**Sibford Park, Colony Road, Sibford Gower,
Oxfordshire, OX15 5RY**

22/03135/F

Proposal: RETROSPECTIVE - Formation of an external swimming pool and erection of two associated plant outbuildings and associated landscaping works

TITLE	Proposed Outbuilding 4 & 5 Plan and Elevations
SCALE	1:100 & 1:200 @ A3
DATE	October 2022
REVISION	PL0
STATUS	PLANNING
DRAWING NUMBER	1-04

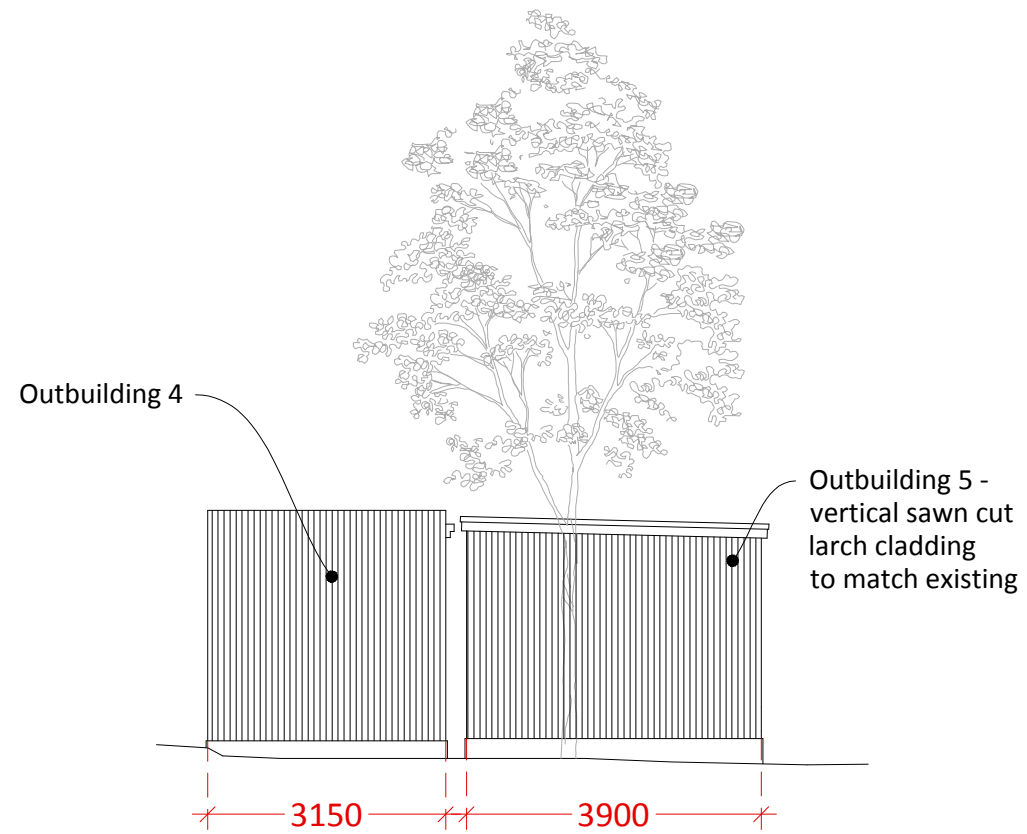
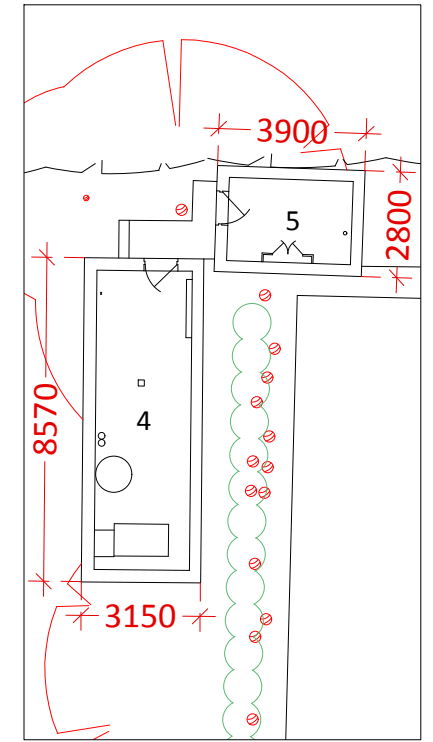
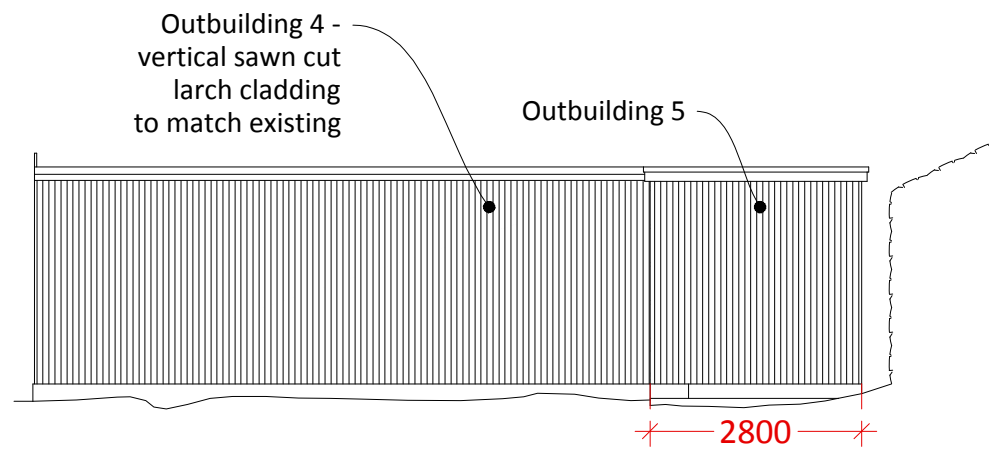
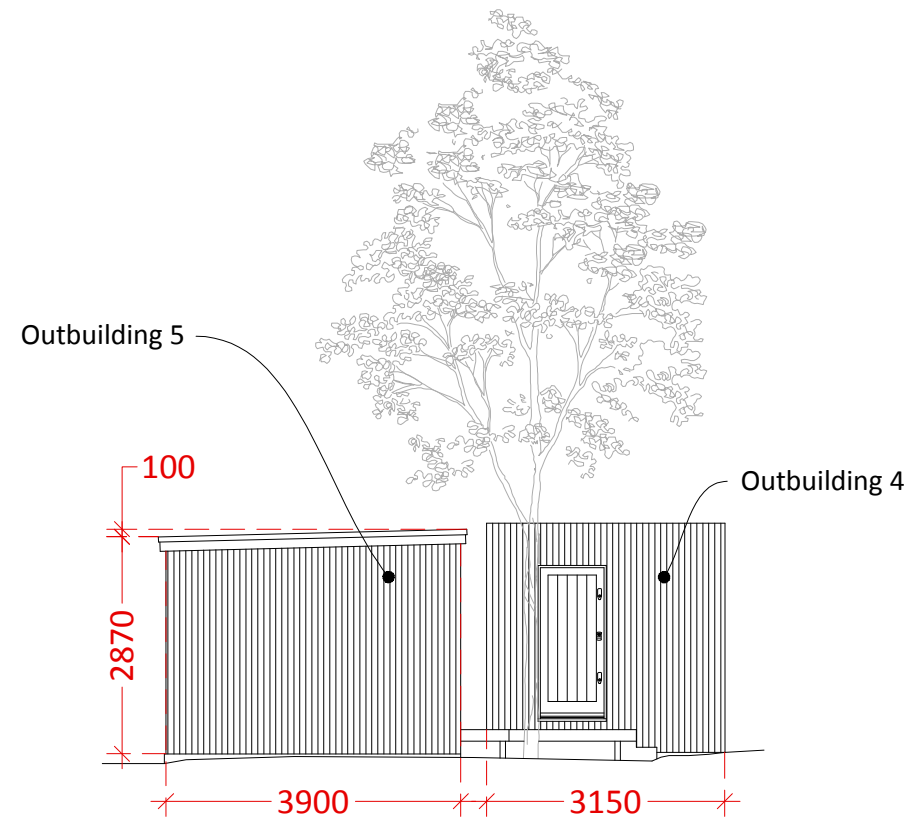
- 7.3. The two outbuildings require planning permission as they have flat roofs and exceed 2.5 metres in height; also one of them is adjacent to the site boundary.

- 7.8. The swimming pool and outbuildings lie to the north-east corner of the property and cannot be seen other than from the dwelling. The pool does not raise the existing level of the garden. Existing Leylandii cypress in the area surrounding the two outbuildings would be removed and a semi-mature 4.5m high hedge of formally pruned native yew would be planted along the northern boundary and between the southernmost new outbuilding (referenced outbuilding 4) and the bordering outbuilding of the neighbour to the east.

- 7.9. The outbuildings are on an acceptable scale and accepted as a necessary functional addition to the site. The outbuildings would have vertical Siberian larch cladding to match the timber cladding of the large barn and the garden store. The buildings would be used as a plant and machinery room associated with the pool and as an electrical hub.

- 7.15. Although noting their proximity to the neighbouring New Barn Farm, having regard to the scale of the outbuildings and the spatial relationships with the neighbouring properties the proposed development is not considered to have any negative impact
